Planning Inspectorate Ref:
EN010112

Conwy County Borough Council Ref:
ENQ/31314

**Application by Awel y Môr Offshore Wind Farm Limited for an Order Granting
Development Consent for the Awel y Môr Offshore Wind Farm project**

Written Representation by Conwy County Borough Council

United Utilities Fazakerley (70.3km)
 Port of Liverpool (63.6km)
 Seaforth (62.9km)

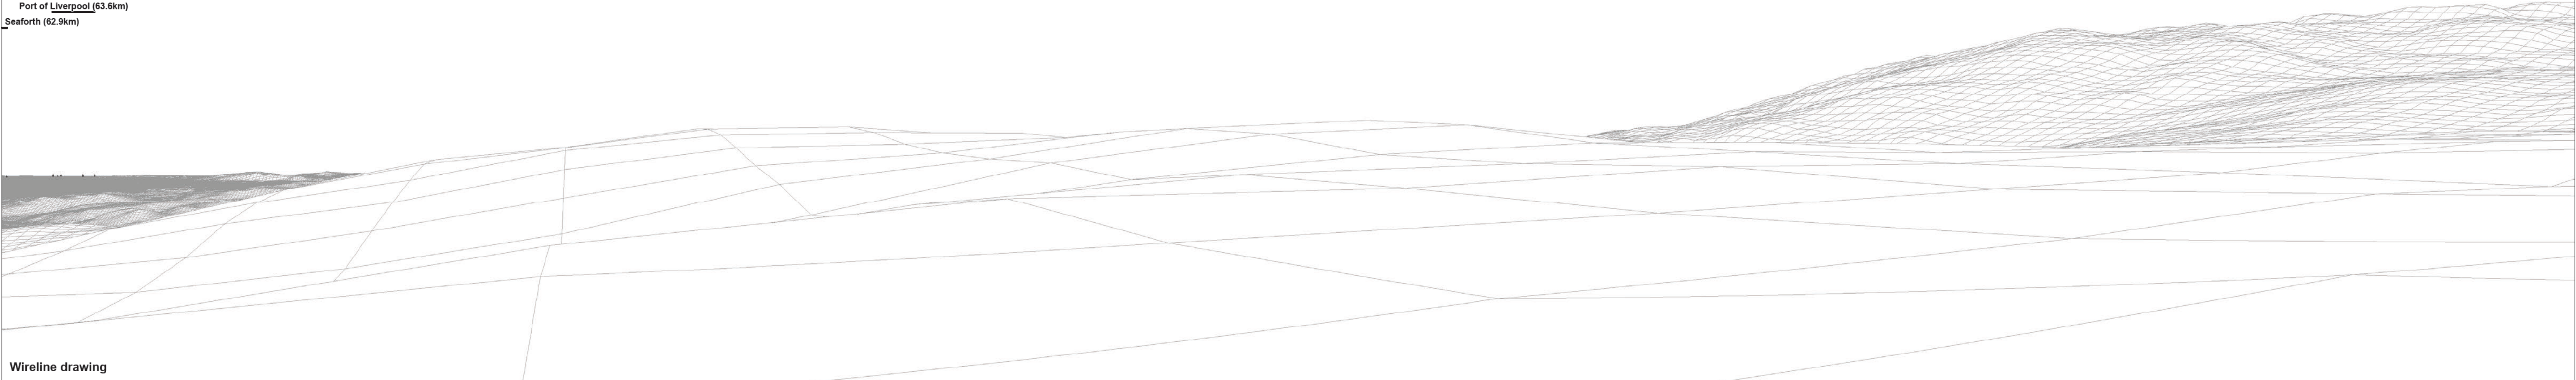
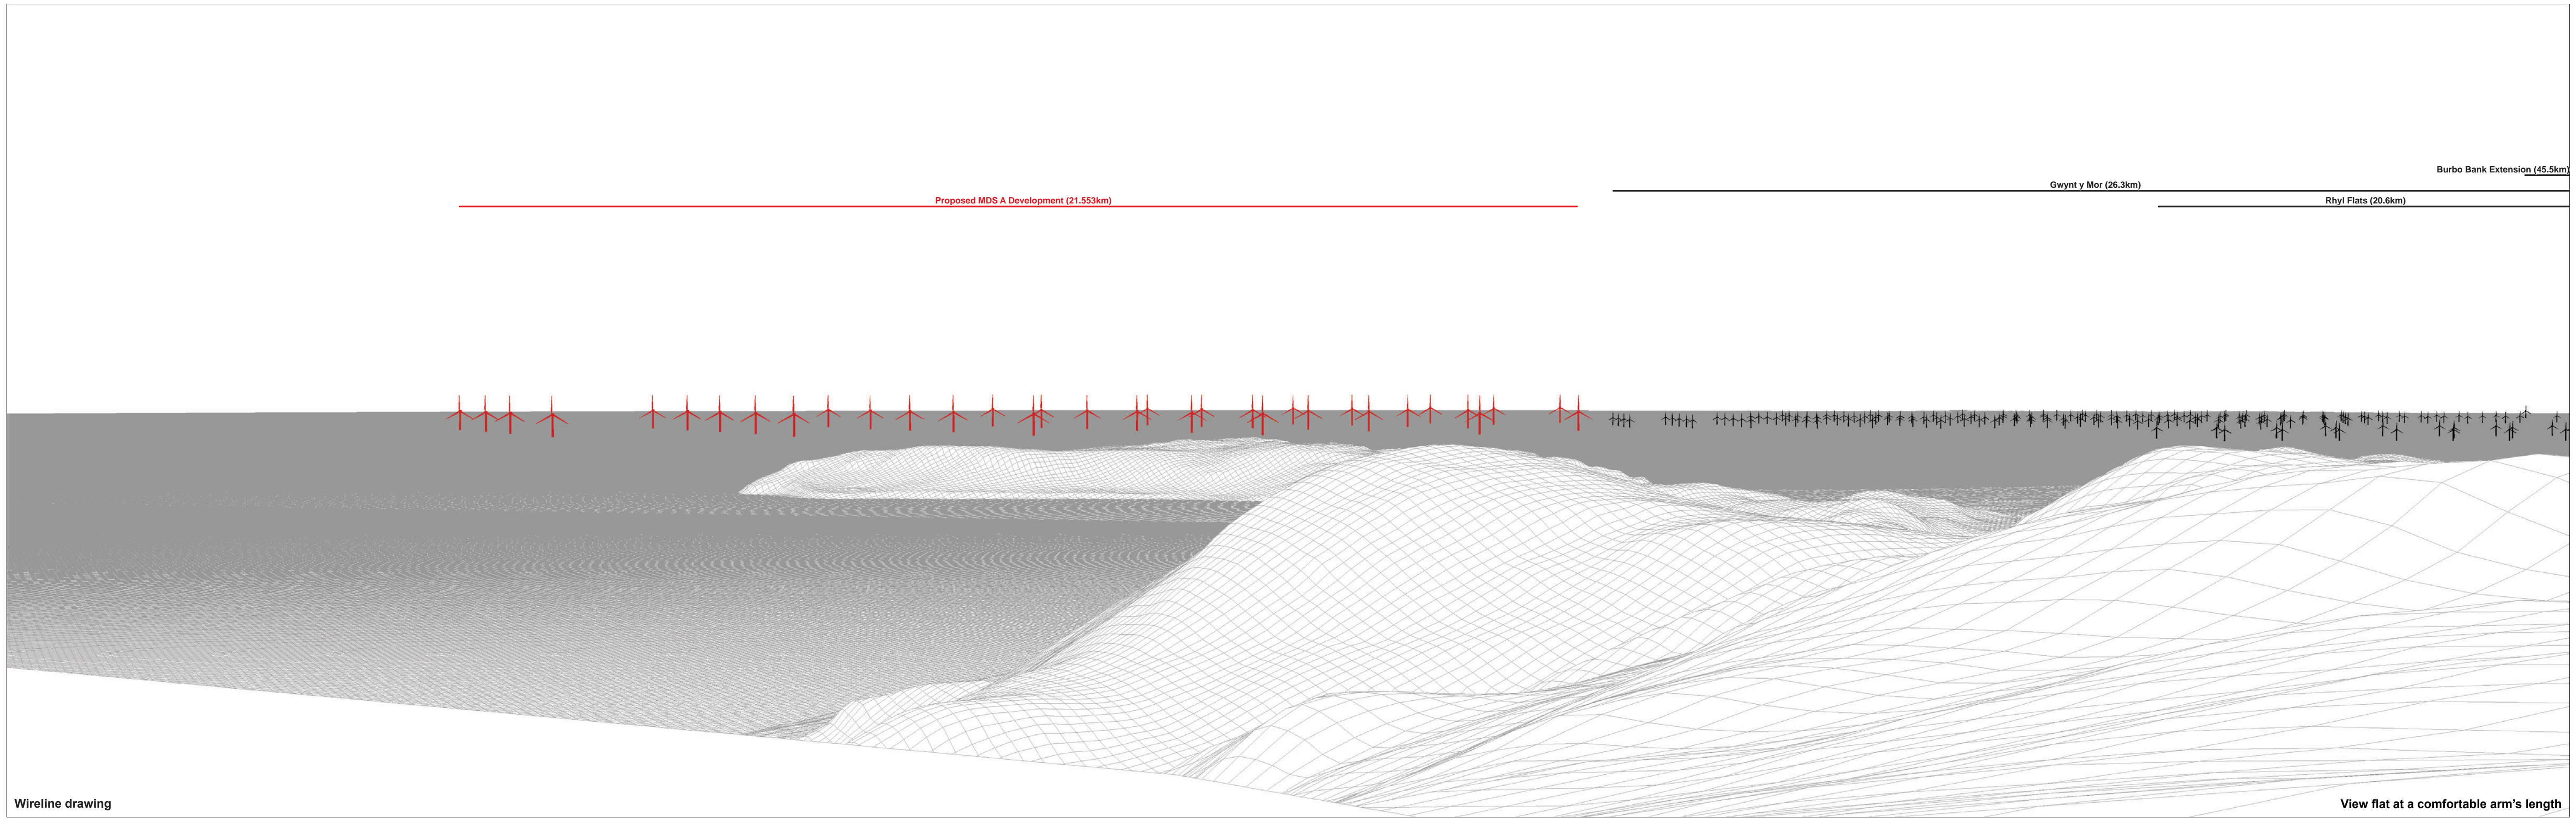
Figure 64b: Cefn Coch stone circle (23.895km)

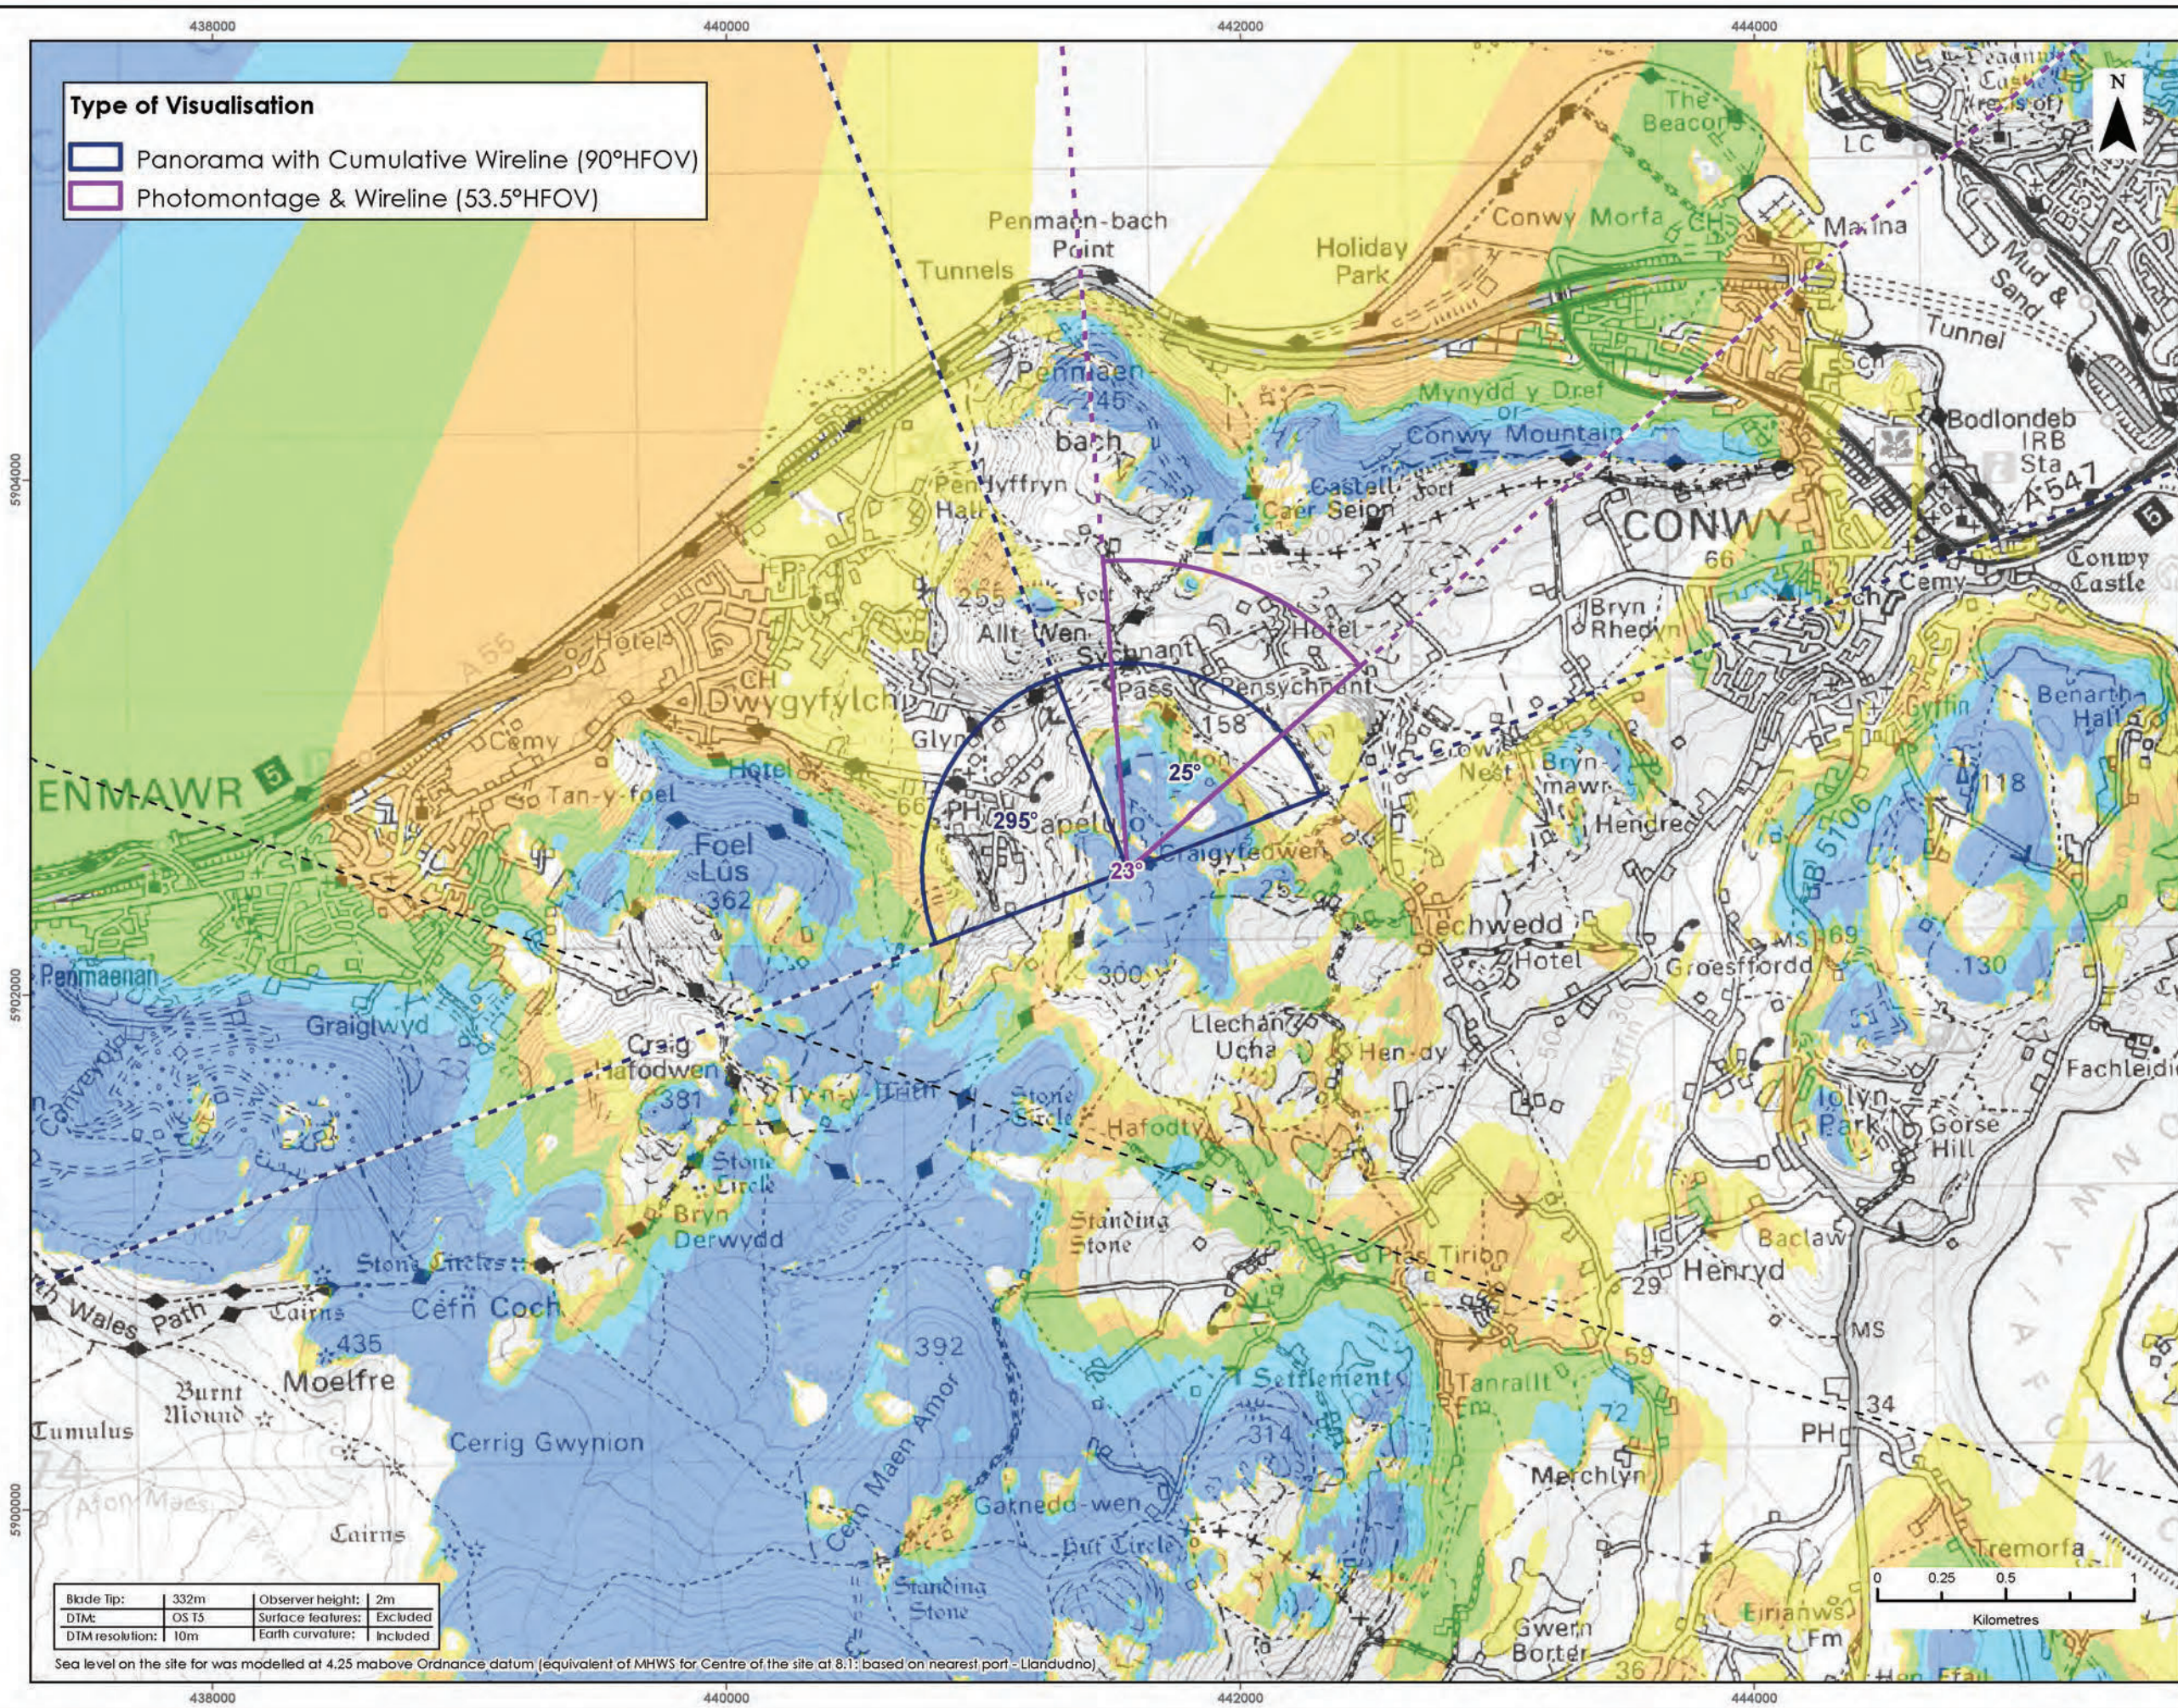
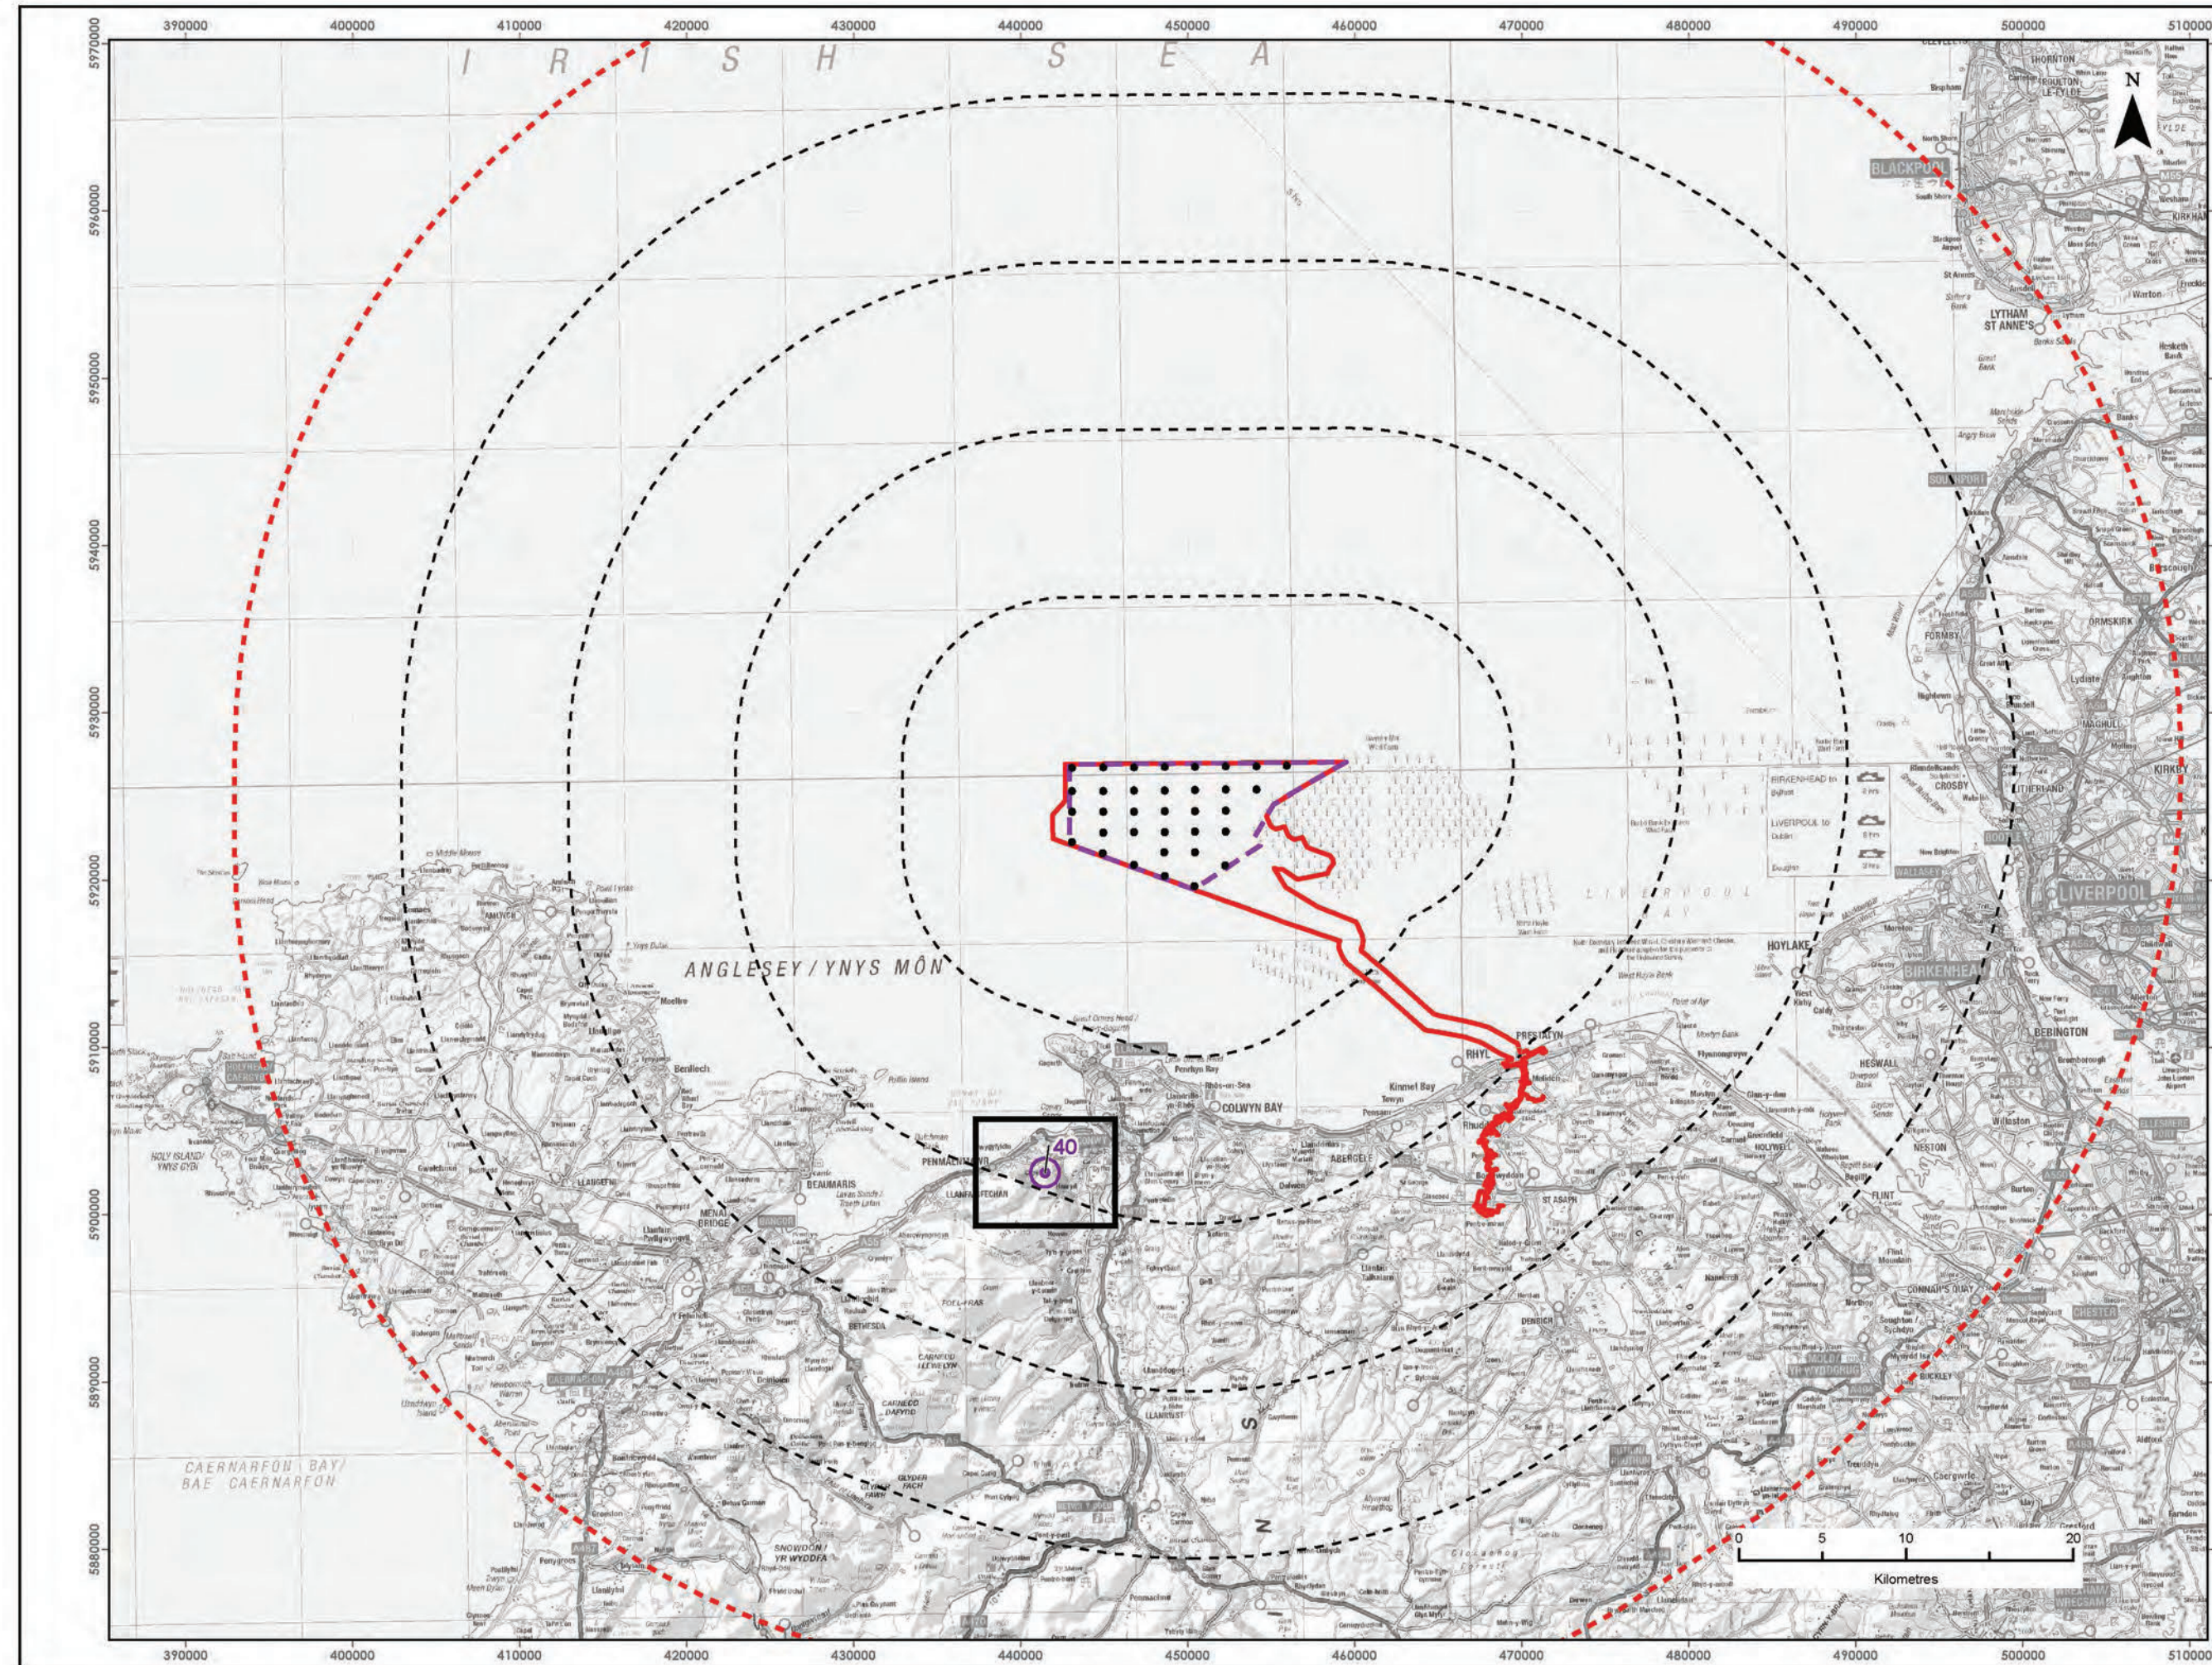
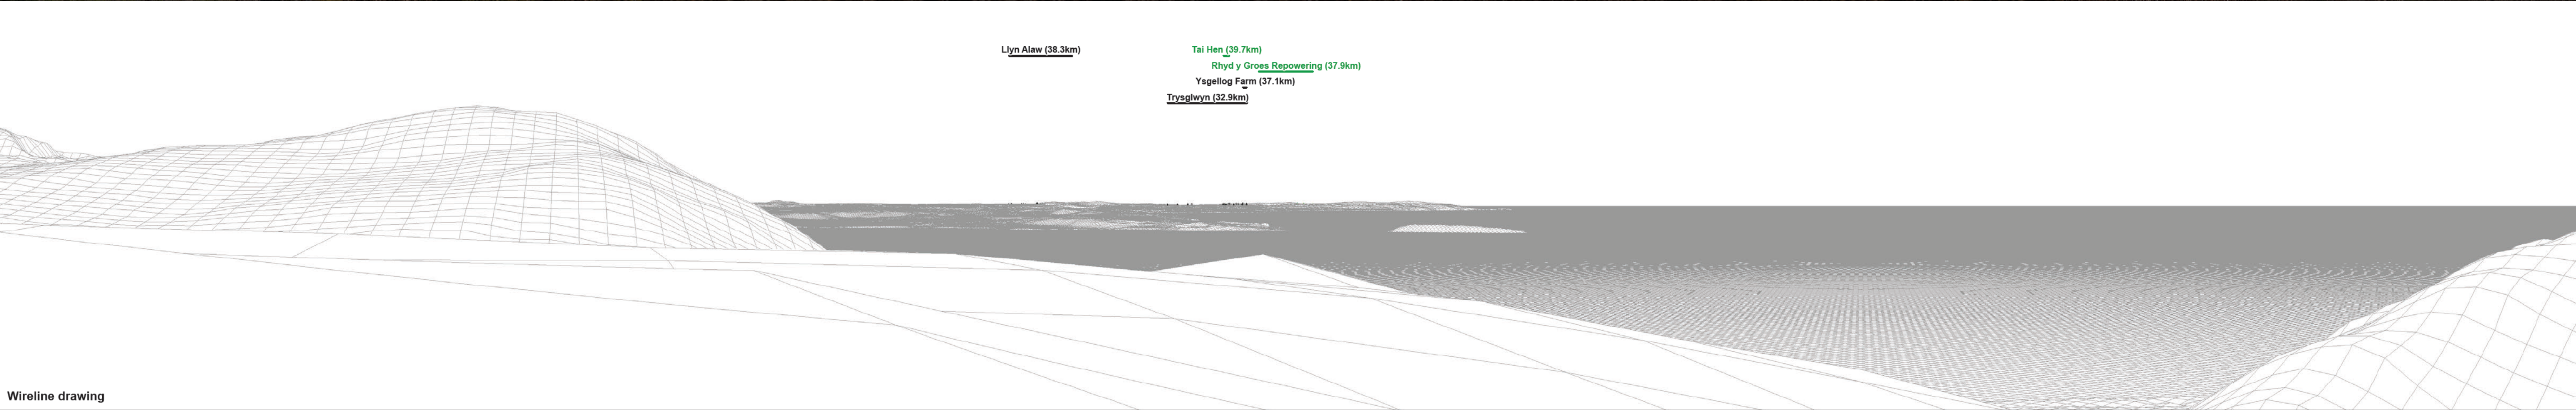
Figure 67c: Above Capelulo (19.13km)
